# Lower Thames Crossing

## 5.4.1.4 Draft Agreed Statement of Common Ground between (1) National Highways and (2) Kent Downs AONB Unit (Clean version)

**DATE: October 2023**  
**DEADLINE: 6**

Planning Inspectorate Scheme Ref: TR010032  
Application Document Ref: TR010032/APP/5.4.1.4

*Local Landscape Character Area boundaries of the Kent Downs AONB LCA, West Kent Downs, Sub-areas Cobham and Shorne*

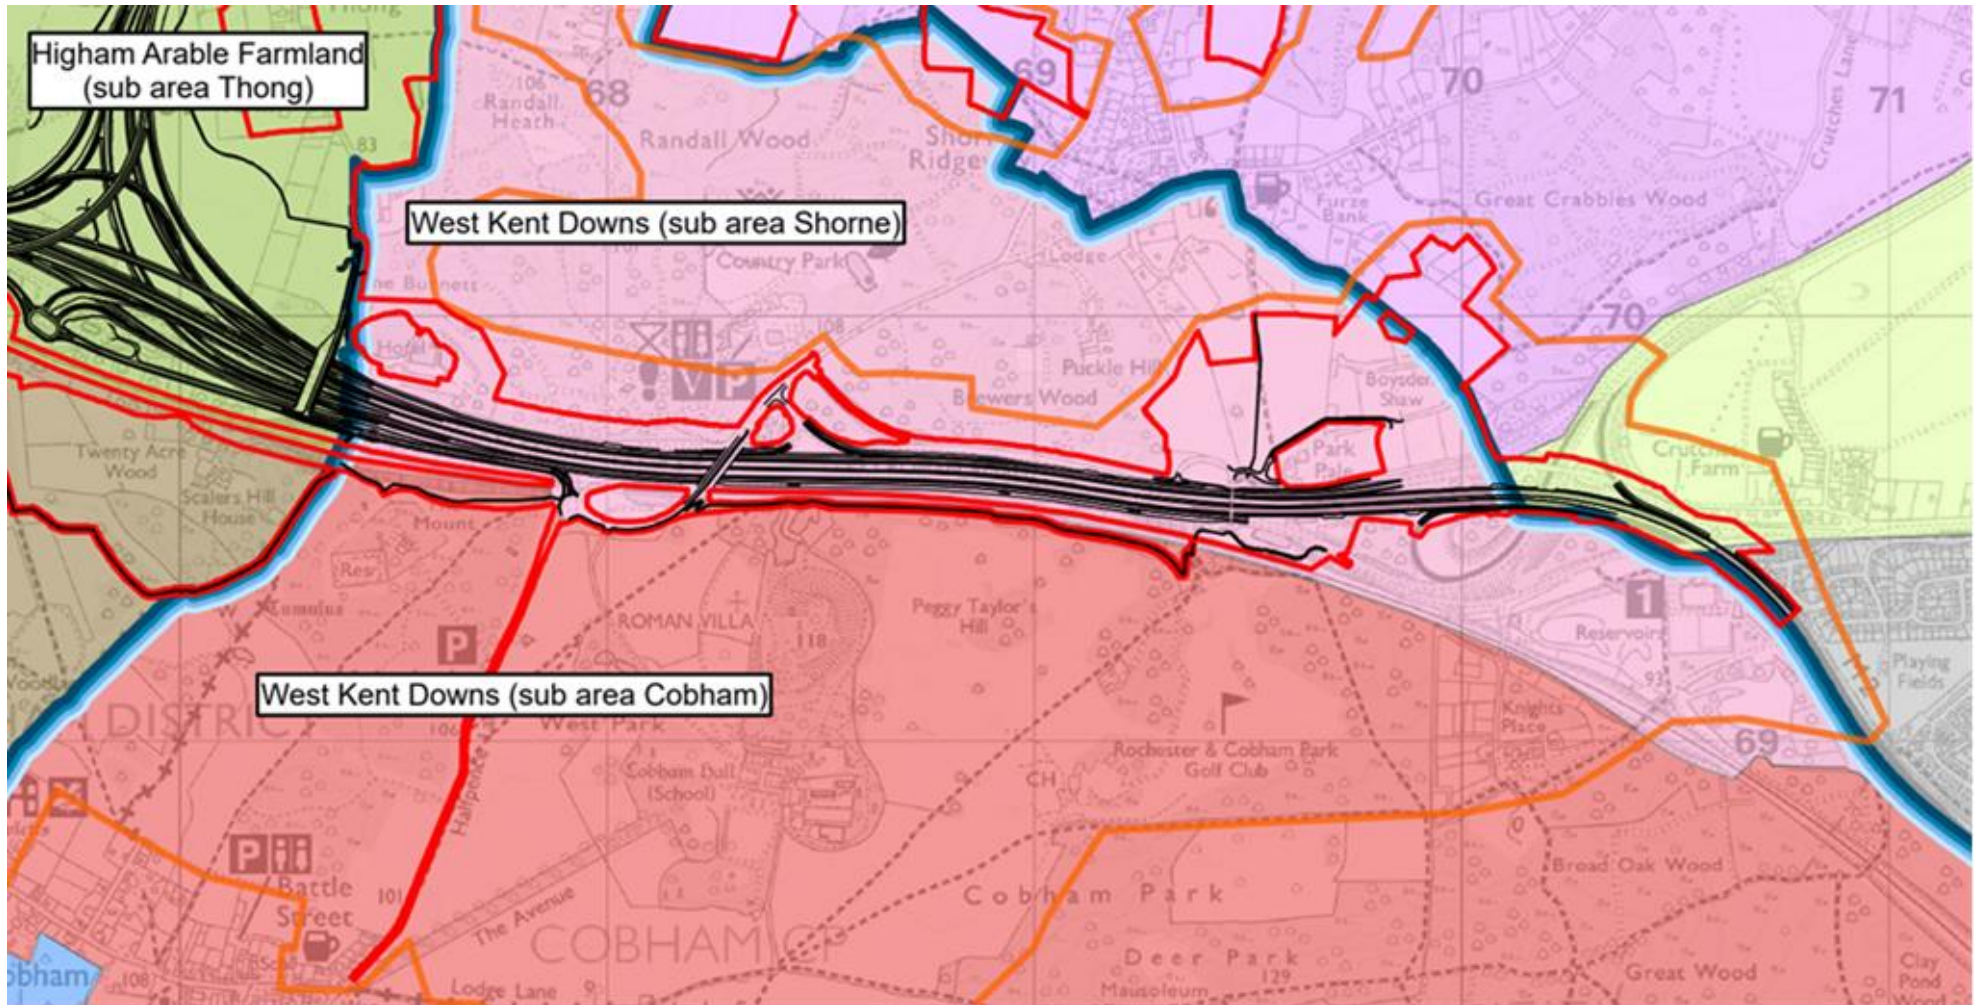
Topic	Item No.	Kent Downs AONB Unit Comment	The Applicant's Response	Application Document Reference	Status
			<p>From the Applicant's review of the West Kent Downs (sub area Cobham) LLCA and from its site visits, it is of the view that HS1 and the associated planting strongly define the northern extent of the Cobham sub area, and it therefore made sense for the Shorne sub area to incorporate the whole width of the A2 corridor, beyond HS1. Notwithstanding this slight difference in the West Kent Downs (sub area Cobham) LLCA boundary for the purposes of the assessment, the effects of the Project are fully assessed either as direct or indirect effects within the West Kent Downs (sub area Cobham) LLCA and/or the neighbouring West Kent Downs (sub area Shorne) LLCA. The findings of these two assessments are then brought together into a combined assessment for the overarching West Kent Downs Landscape Character Area (LCA) 1A. The combined effects reported in the landscape impact summary in Tables 7.33 and 7.34 in Section 7.9 of ES Chapter 7: Landscape and Visual and the overall conclusion of the landscape and visual impact assessment would therefore not differ if the Cobham and Shorne sub area boundary is drawn in a different location.</p>
